Project Title: NM Sol **Building Permit #:** _____ **Hydrology File #:** _____
DRB#: _____ **EPC#:** _____ **Work Order#:** _____
Legal Description: Lot 2-B, Tract S-1, Atrisco Business Park, Unit 2, City of Albuquerque, Bernalillo County, NM
City Address: 7401 Los Volcanes NW

Re: NM Sol/ Phase 1 Tenant Addition
7402 Los Volcanes Rd. NW
Traffic Circulation Layout
Architect's Stamp 03-28-23 (J10-D027)

The following are our responses to your comments on the above TCL.

AS101 **TCL**

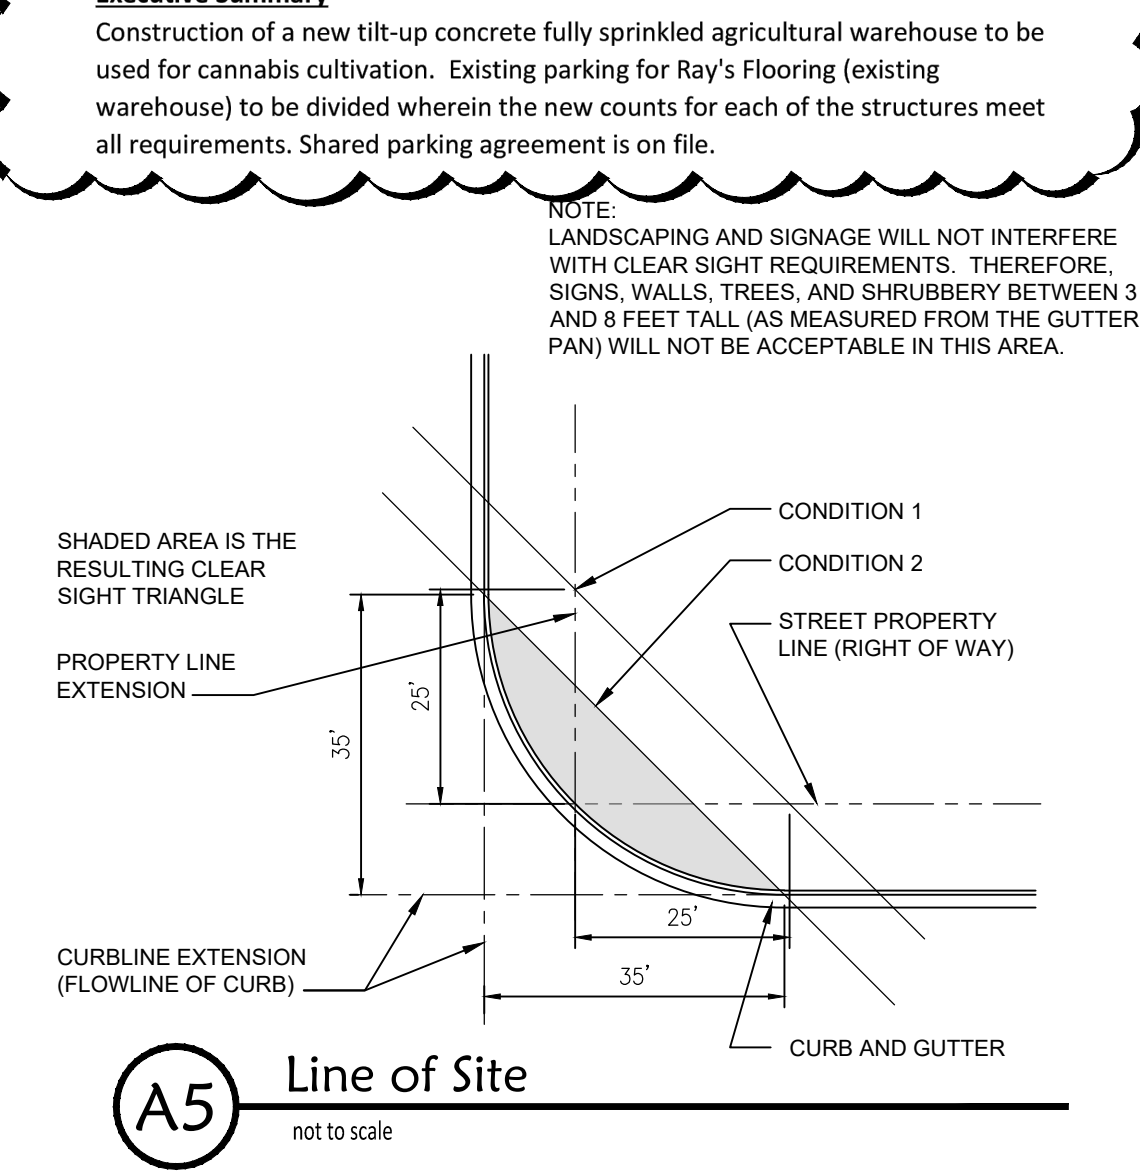
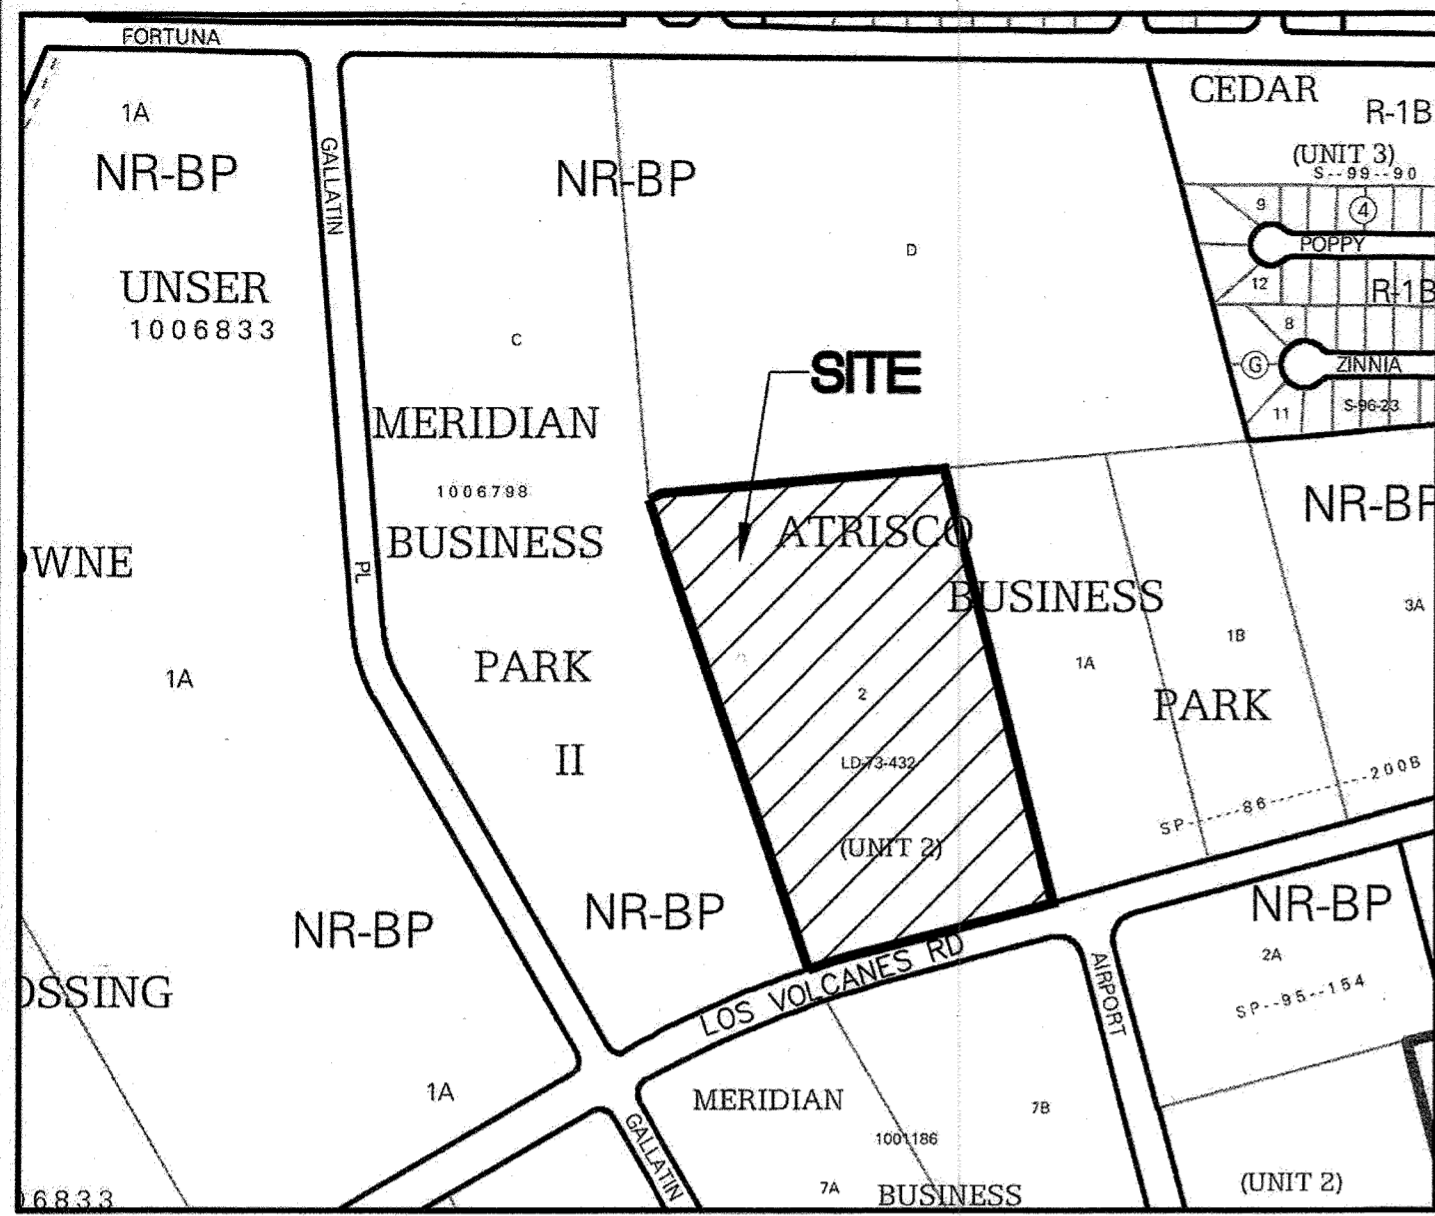
1. Identify all existing access easements and rights of way width dimensions.
 - a. Review AS101
2. Is the proposed Warehouse behind or in front of the existing building? Please clarify.
 - a. Review AS101
3. Please show the site accesses on the site plan, and site accesses must be updated to the current ADA standard.
 - a. Review AS101
4. Please show the dimensions for all the proposed parking spaces.
 - a. All parking is existing, review AS101
5. Show all drive aisle widths and radii. Some dimensions are not shown.

- a. Review AS101 and AS102
6. Per the IDO, a 6 ft. wide ADA accessible pedestrian pathway is required from the public sidewalk to the building entrances. Please clearly show this pathway and provide details.
 - a. Pathway updated, see AS101
7. Per DPM, a 6 ft. wide ADA accessible pedestrian pathway is required from the ADA parking stall access aisles to the building entrances. Please clearly show this pathway and provide details.

- a. Access shown, refer to AS101, AS102
- 8. ADA accessible pedestrian pathway should not be placed behind parking space or adjacent to a vehicular way. Vehicle and pedestrian/wheel chair conflicts should be avoided as much as possible.

- a. Refer to AS102
- 9. Curbing should be installed to delineate landscape, parking, and pedestrian ways and identify points of access. Please call out detail and location of barrier curb.

- a. Asphalt is shown on AS101
- 13. Show the clear sight triangle and add the following note to the plan: "Landscaping and signage will not interfere with clear sight requirements. Therefore, signs, walls, trees, and shrubbery between 3 and 8 feet tall (as measured from the gutter pan) will not be acceptable in the clear sight triangle."

- a. Clear sight triangle detail added to sheet AS101
- 14. Please specify the City Standard Drawing Number when applicable.
 - a. shown
- 15. Add a note stating "All broken or cracked sidewalk must be replaced with sidewalk and curb & gutter." A build note must be provided referring to the appropriate City Standard drawing.

- a. See AS101
- 16. Traffic Studies: See the Traffic Impact Study (TIS) thresholds. In general, a minimum combination of 100 Vehicles entering and exiting in the peak hour warrants a Traffic Impact Study. Visit with Traffic Engineer for determination, and fill out a TIS Form that states whether one is warranted. In some cases, a trip generation may be requested for determination (Contact Matt Grush: mgrush@cabq.gov).
